Vesta Property Group Ltd
Lane to the North of Fenay Lane, Almondbury

Planning Statement Addendum

September 2026

Job No.	26-255	Scale @ A1	As Shown
Drawing No.	EW09		Revision P02

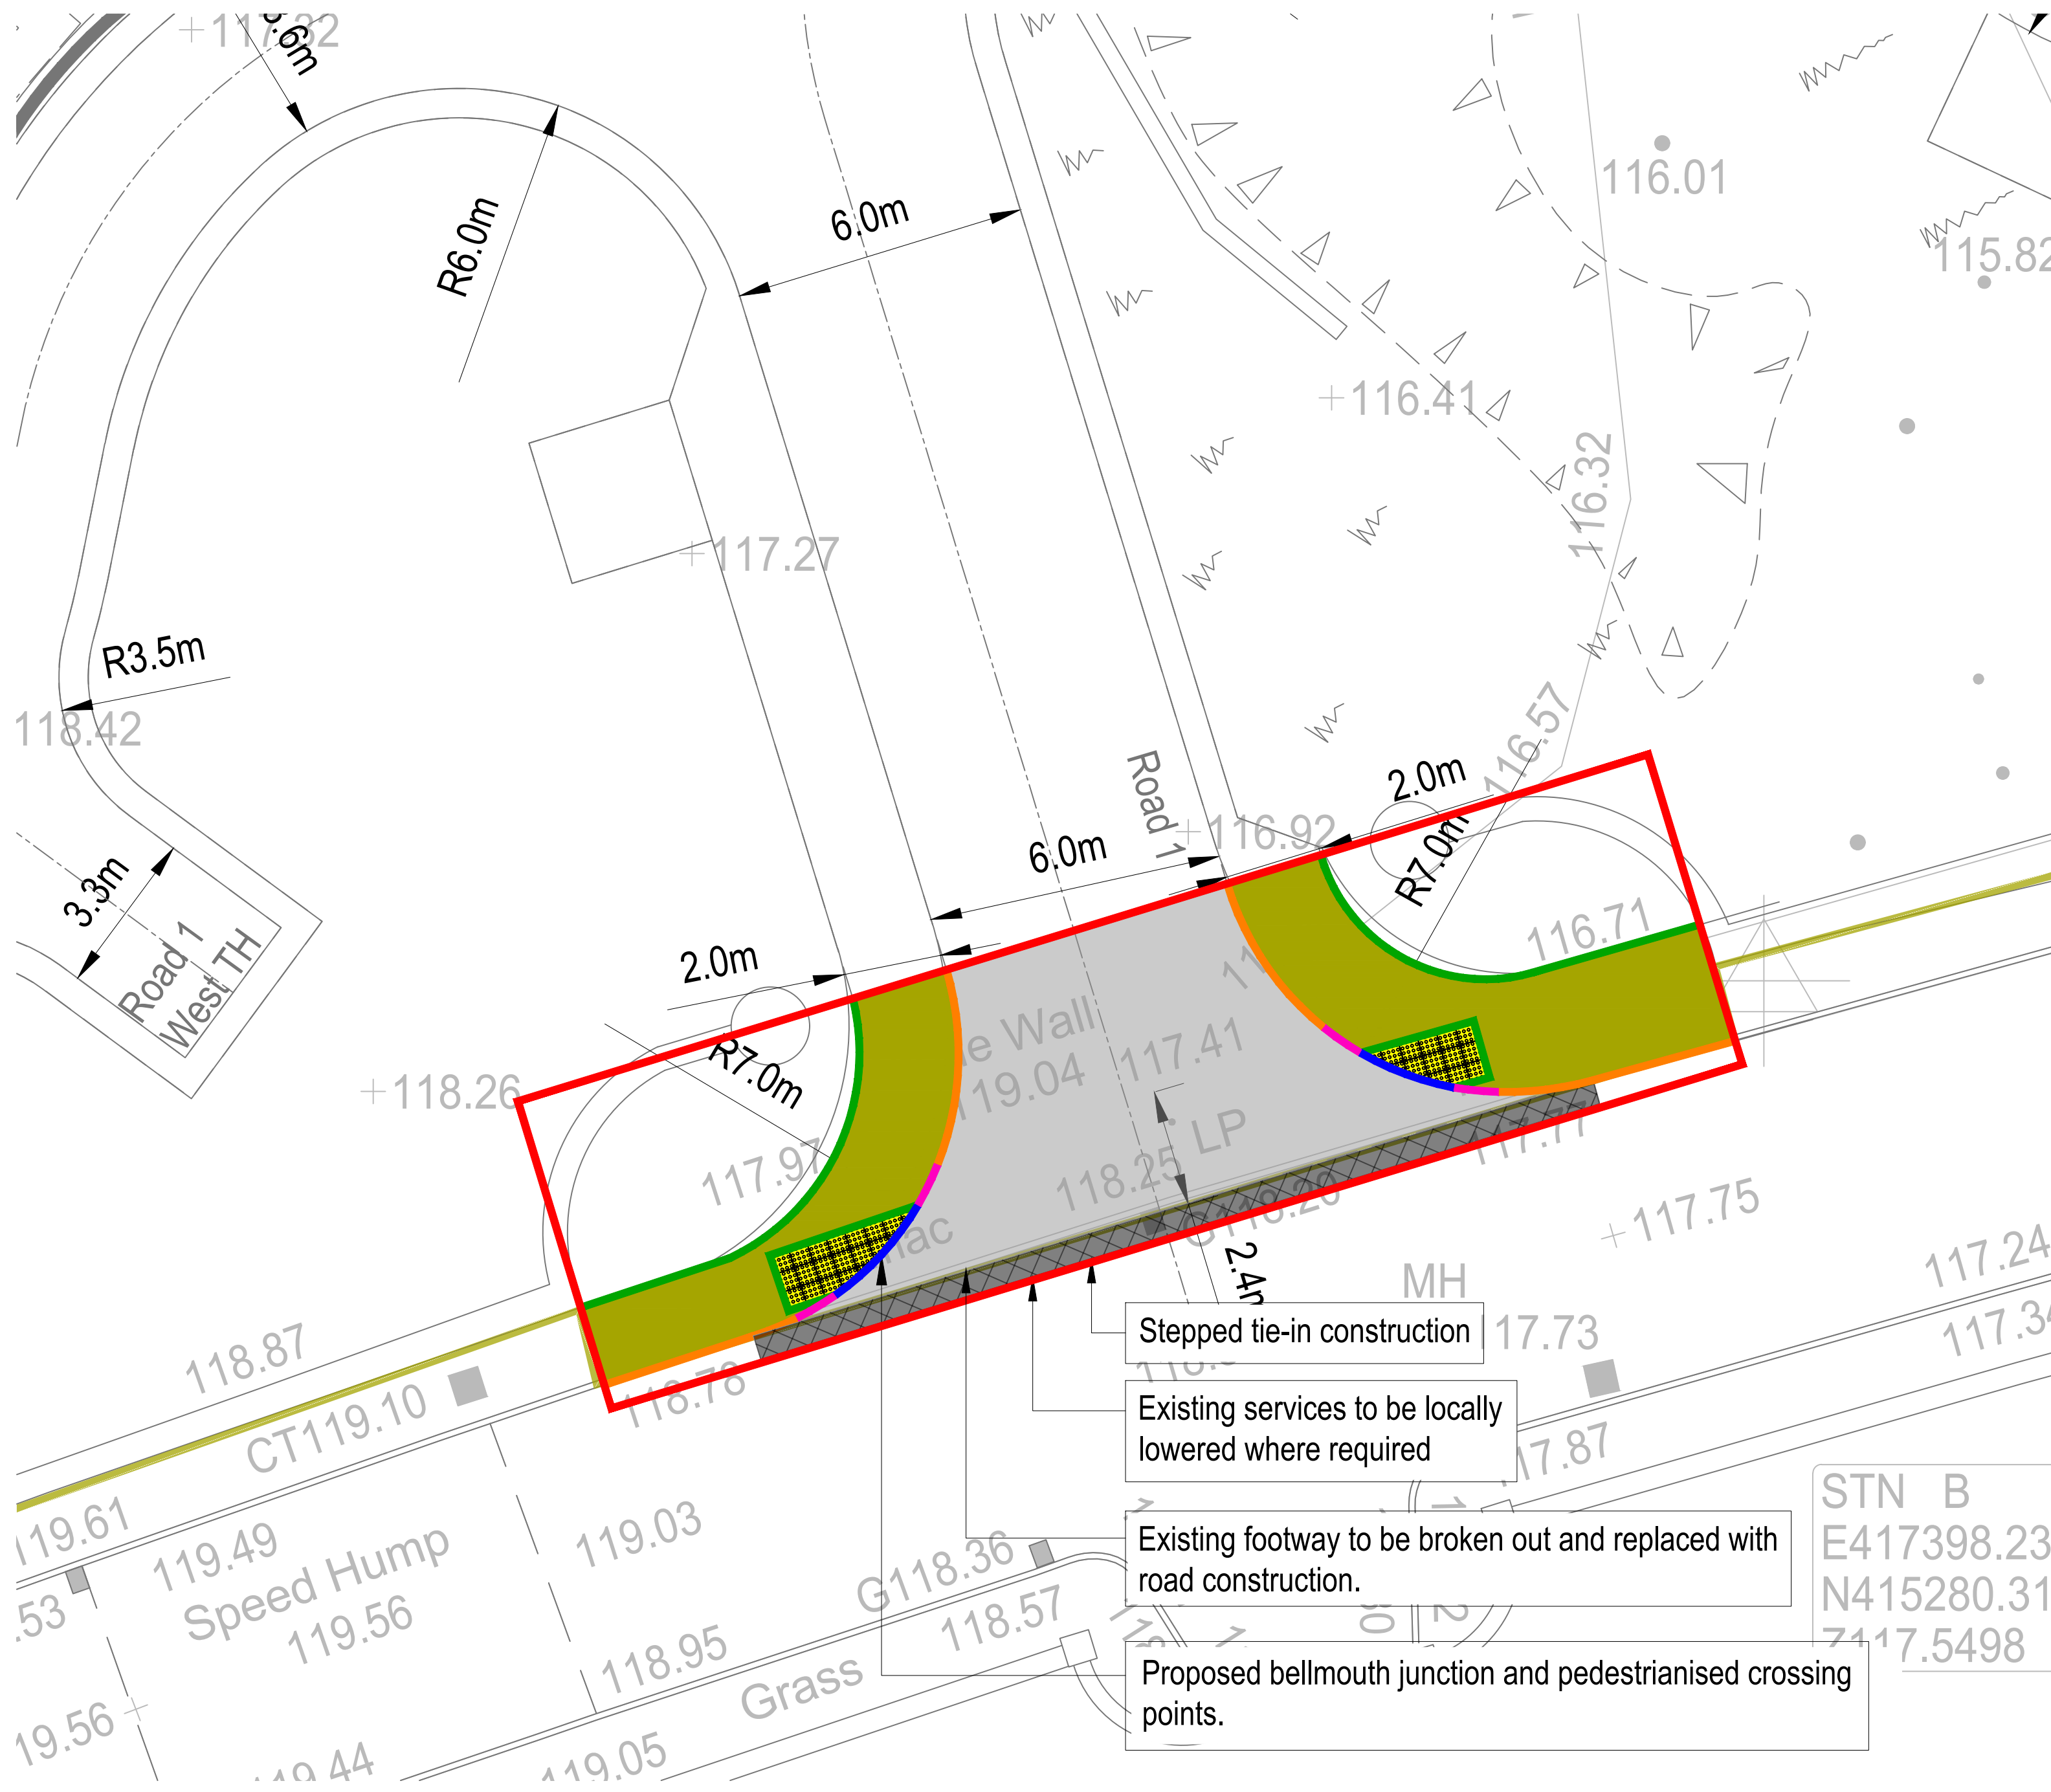
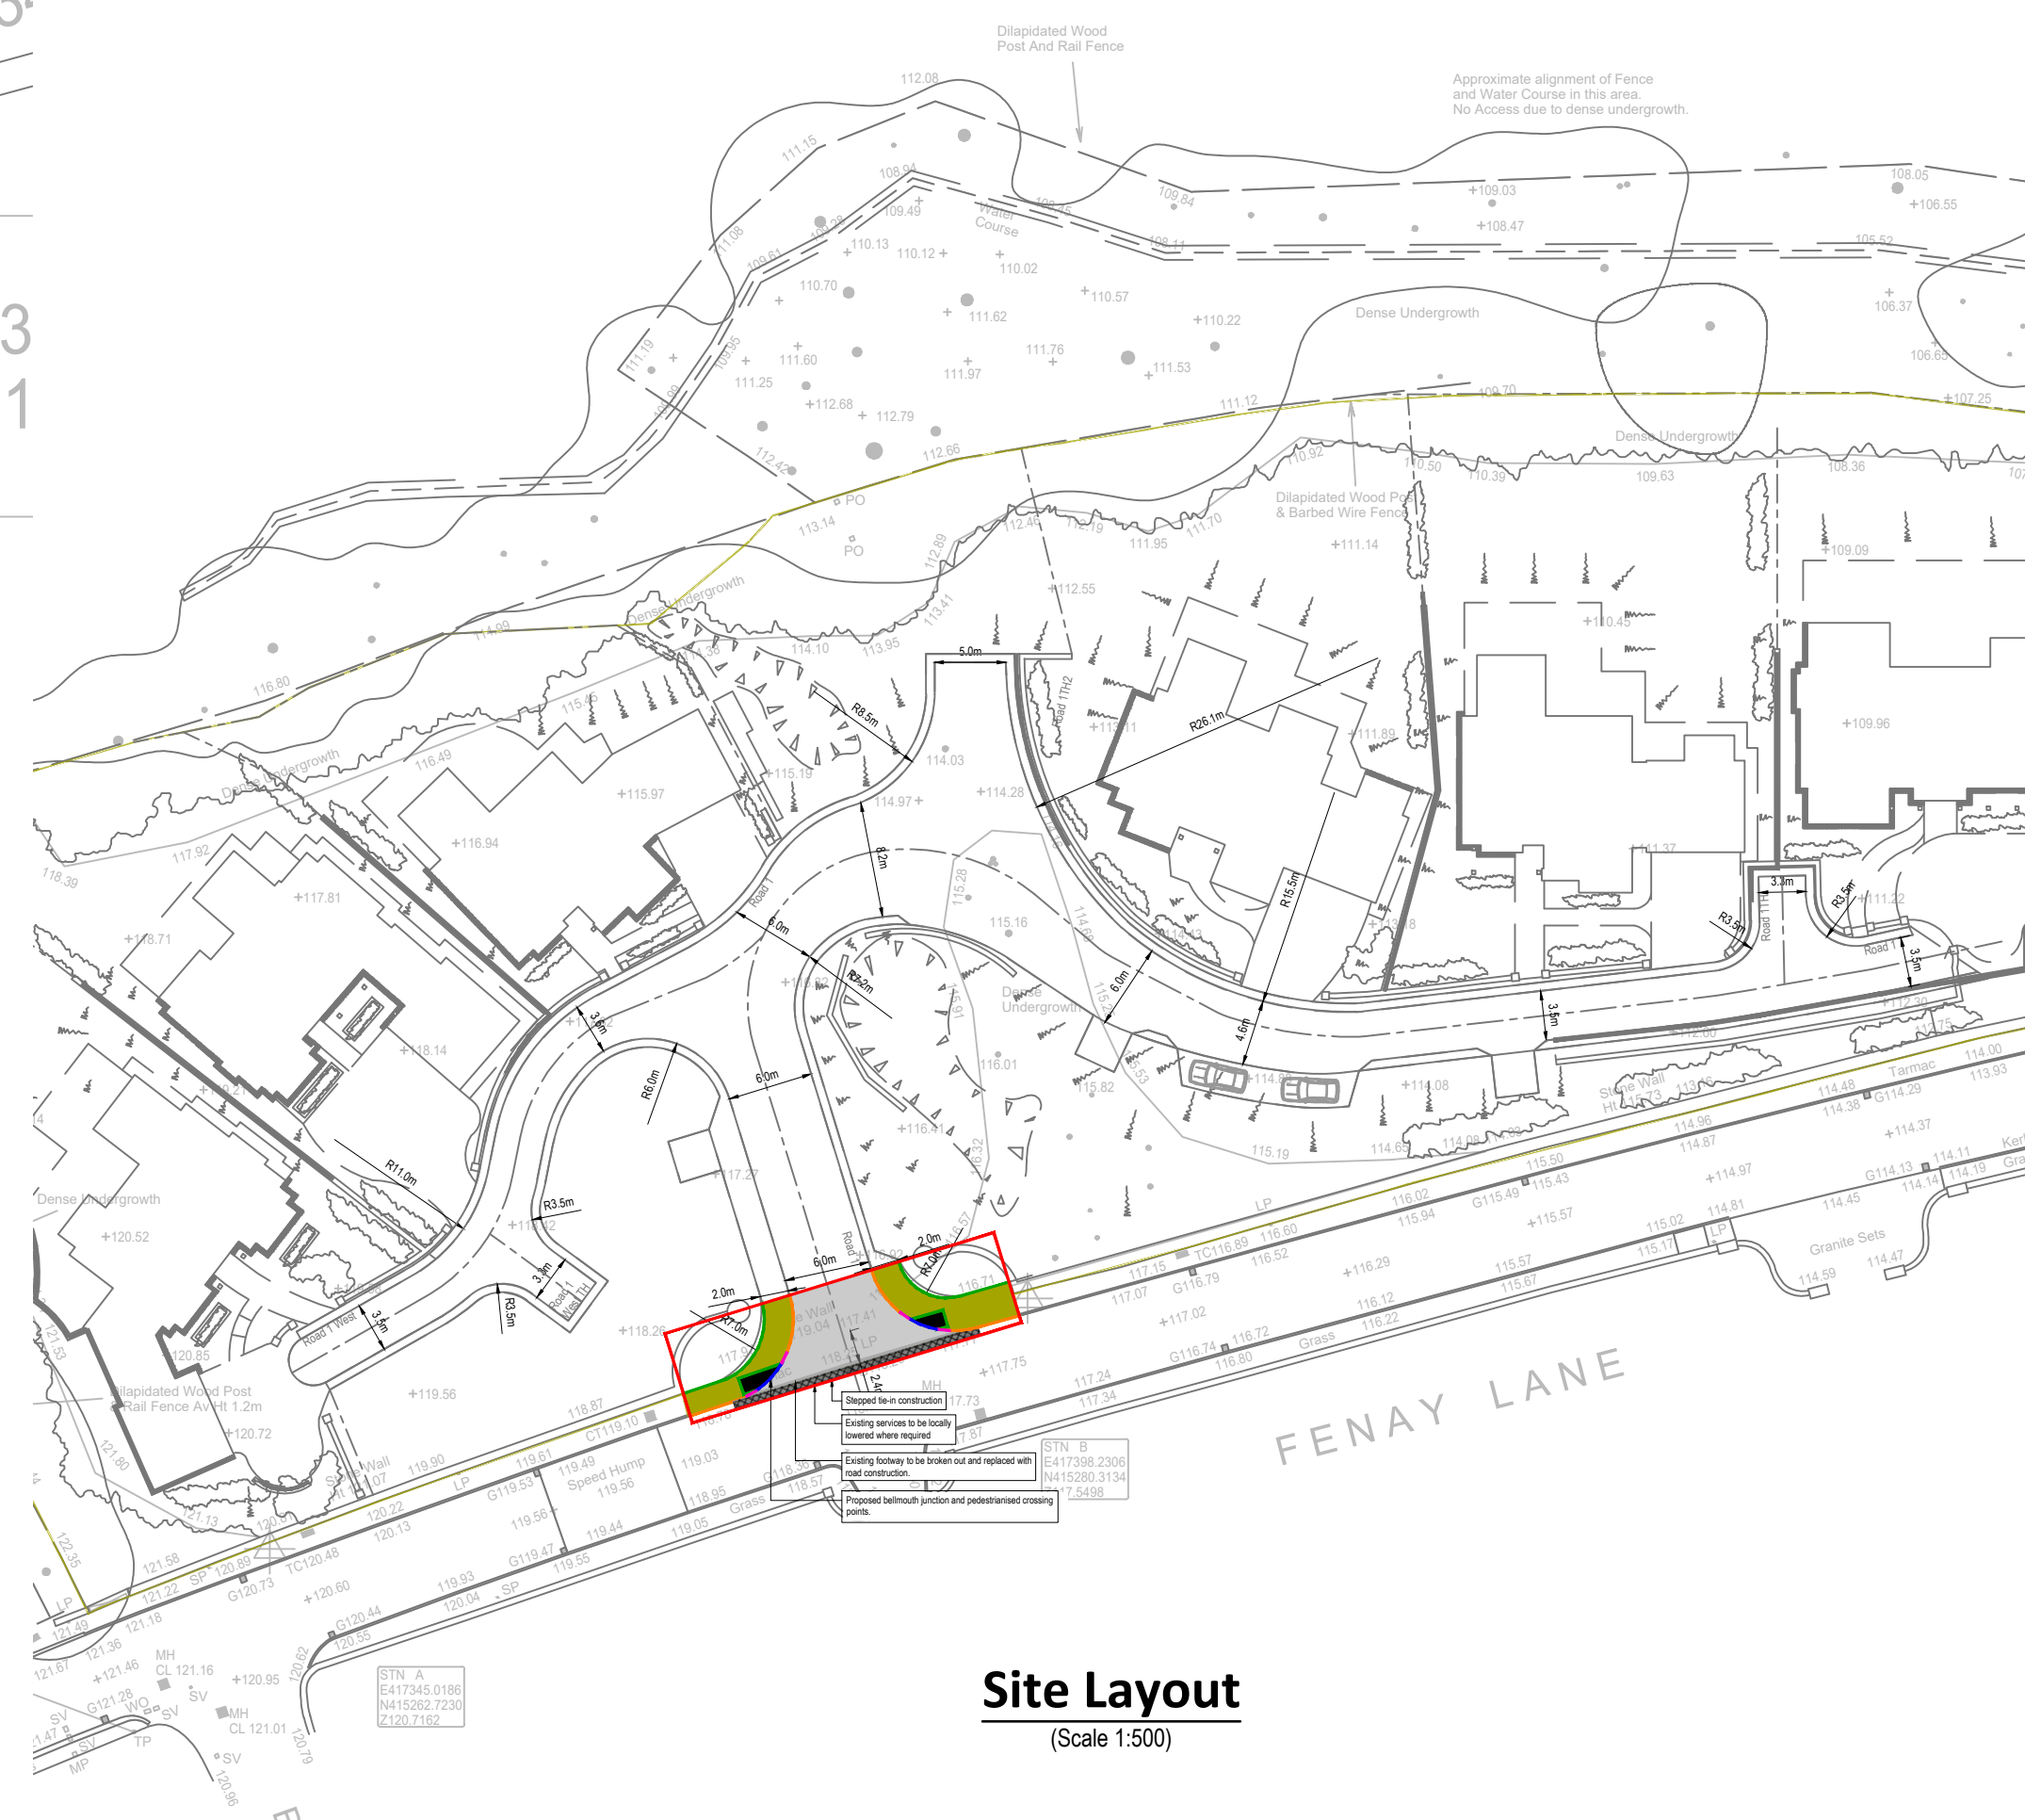
- Despite the swept paths being mostly acceptable, the left turn is too tight to the kerb line and adjustment will be necessary
- A Stage 1 Road Safety Audit is required prior to determination

- A Section 278 agreement will be required to construct new access
- A plan showing extent of road adoption is required, this will then need to go through the Section 38 highway agreement process
